AGENDA ITEM: DFT Project Number: PR-2023-008423

Application Number: SI-2023-00606 Project Name: 4821 Pan American West – Lexus

CODE ENFORCEMENT COMMENTS & APPLICANT RESPONSES

Request: Major Site Plan Amendment

**C06.0**

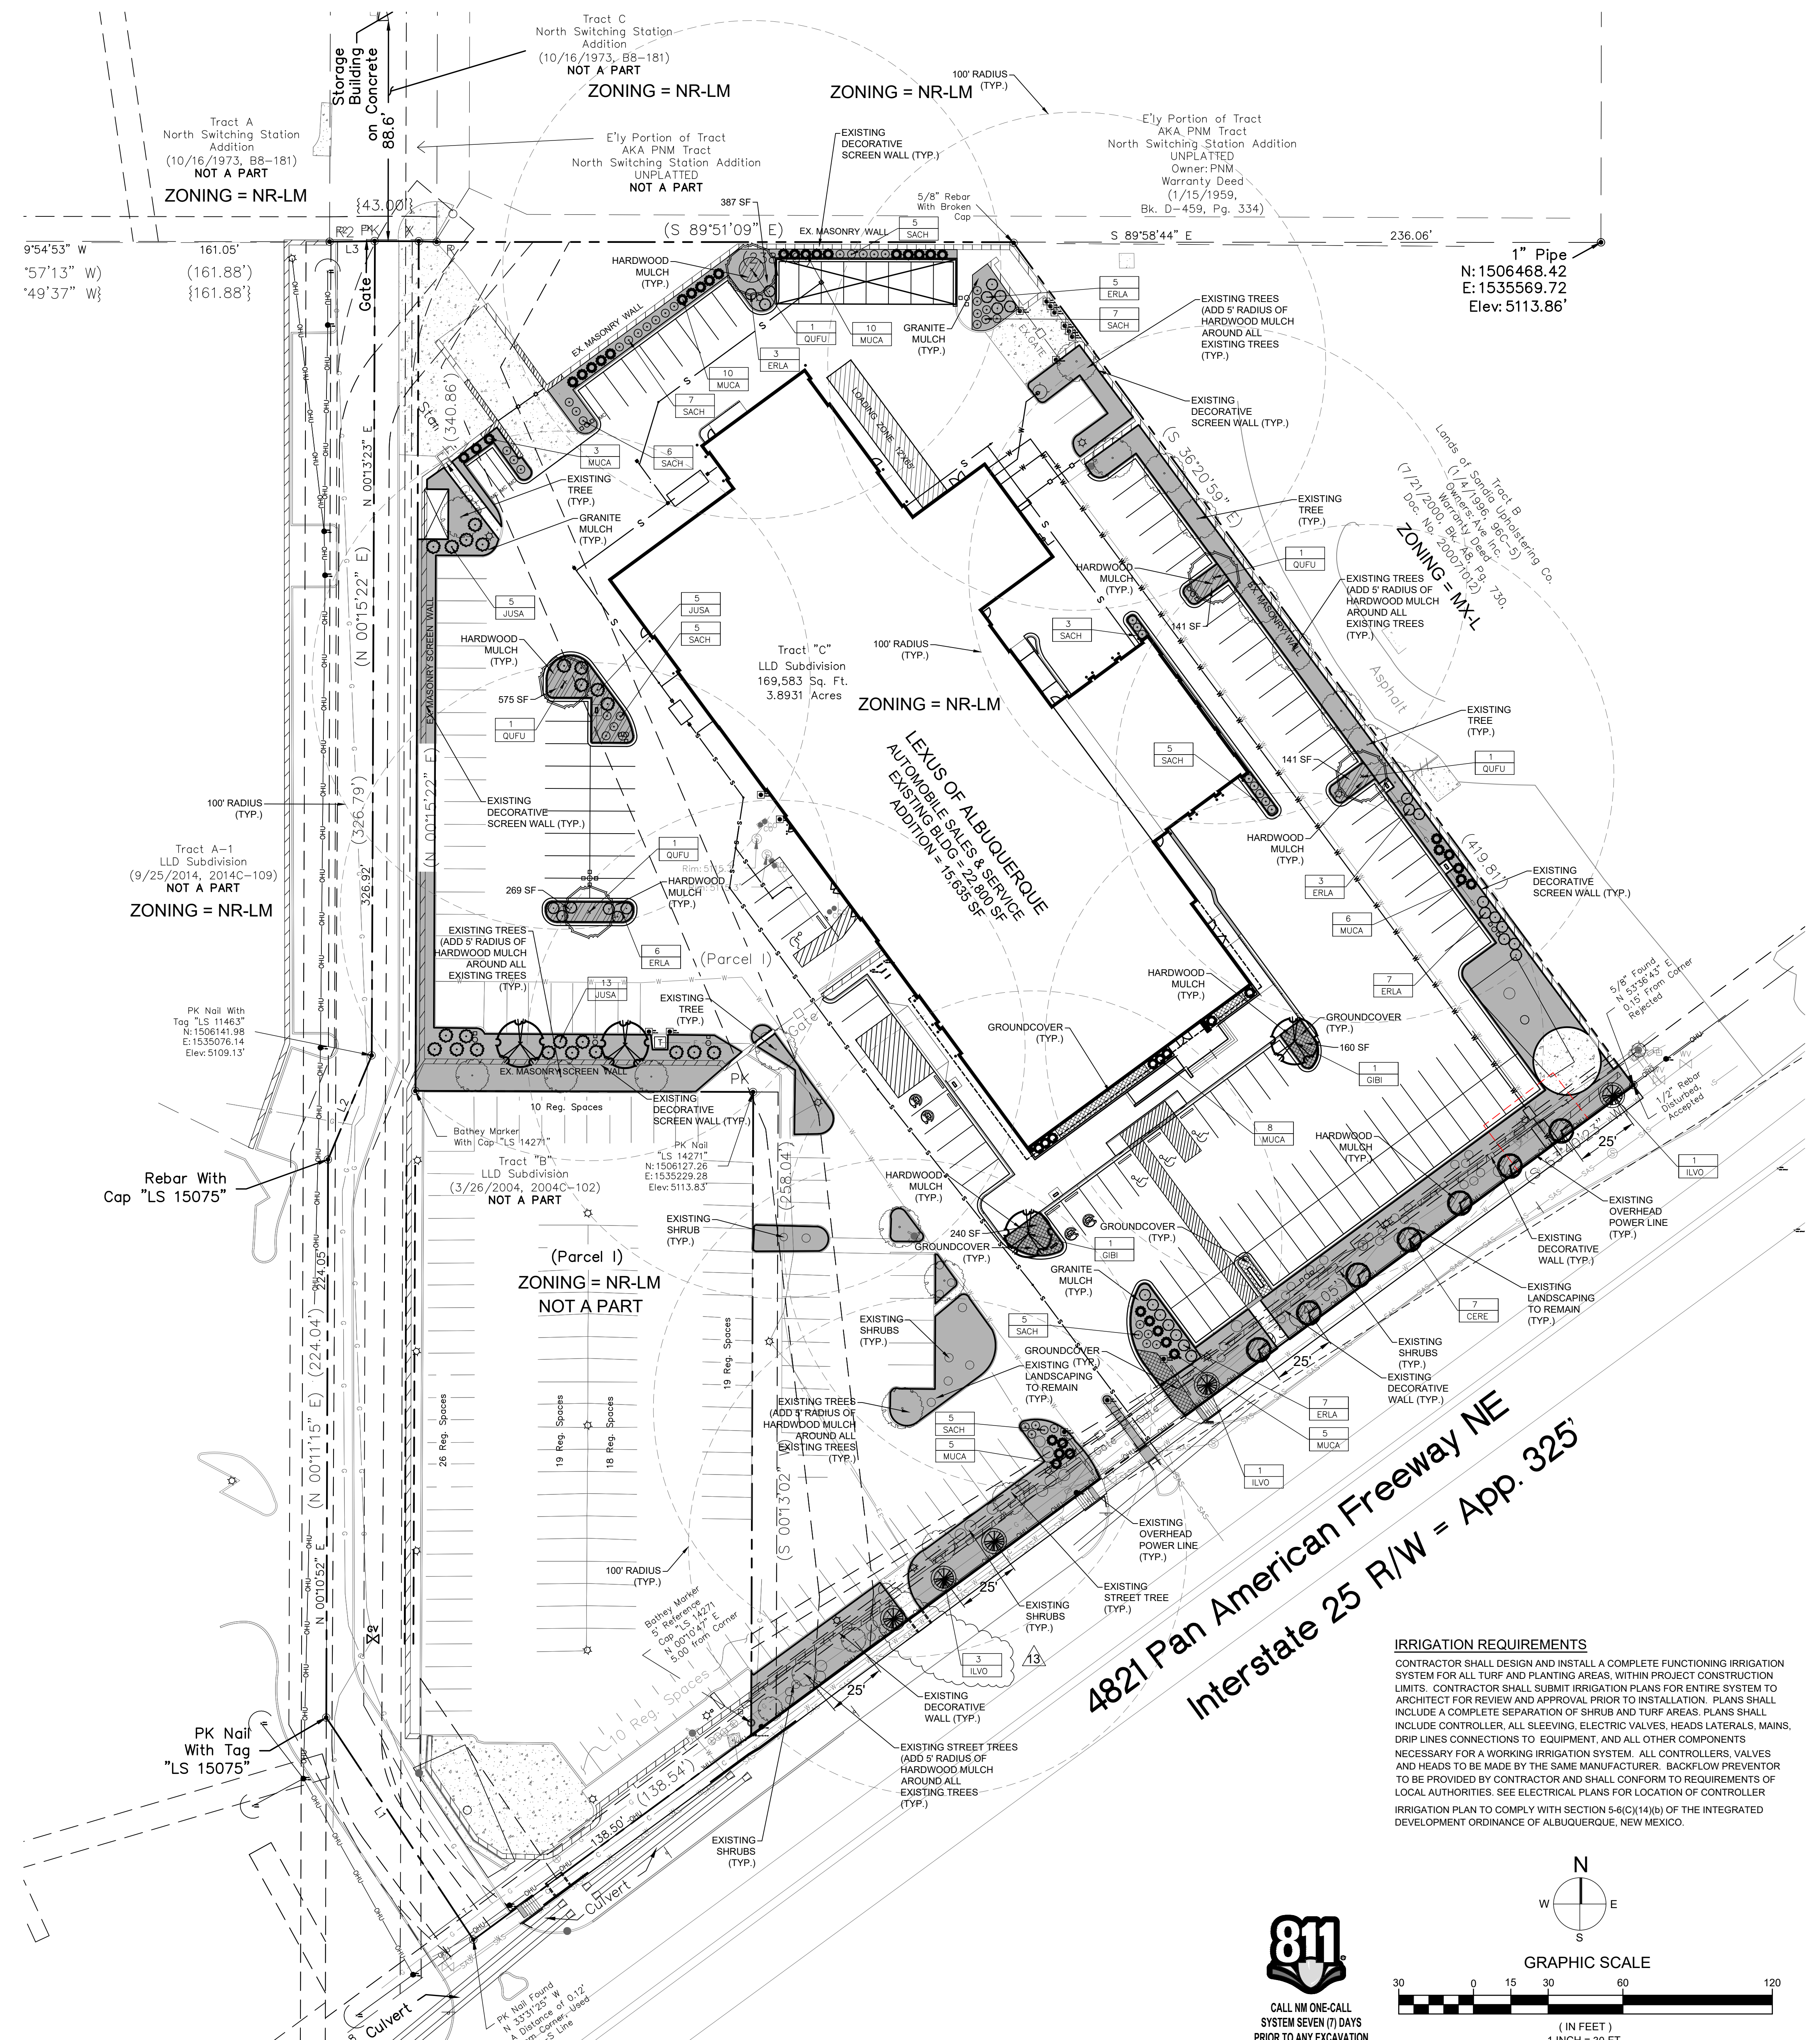
***Plans will need to demonstrate compliance of landscaping requirements.**

Provide calculations & detail. Please note that a minimum of 15 percent of the net lot area shall contain landscaping.

- Replace any dead and or diseased plant materials along the southwest edge of the project.
- Per 14-16-5-6 (C)(5)(e) organic mulch is required as ground cover under trees within a 5-foot radius around the tree trunk, but not directly against the trunk. In these areas, weed barrier fabric is prohibited. **Organic Mulch note is required on the landscaping plan. We recommend the same for the existing trees.**

- **Add the plant sizes, coverages and water use for each plant on the plant legend.** In order to comply with 5-6(A)(4) please consider adjusting any plant material if required. You can refer to 'Xeriscaping The Complete How-To Guide' for native/adapted plant palette, sizes and water use.
PLANT SIZES, COVERAGES AND WATER USE ADDED TO PLANT LEGEND, SHEET C06.0.

SEE REVISED LANDSCAPE PLAN FOR ADDITIONAL INFORMATION, SHEET C06.0.

NOTE ADDED TO LANDSCAPE PLAN TO REQUIRE ORGANIC MULCH FOR ALL PROPOSED AND EXISTING TREES, SHEET C06.0.
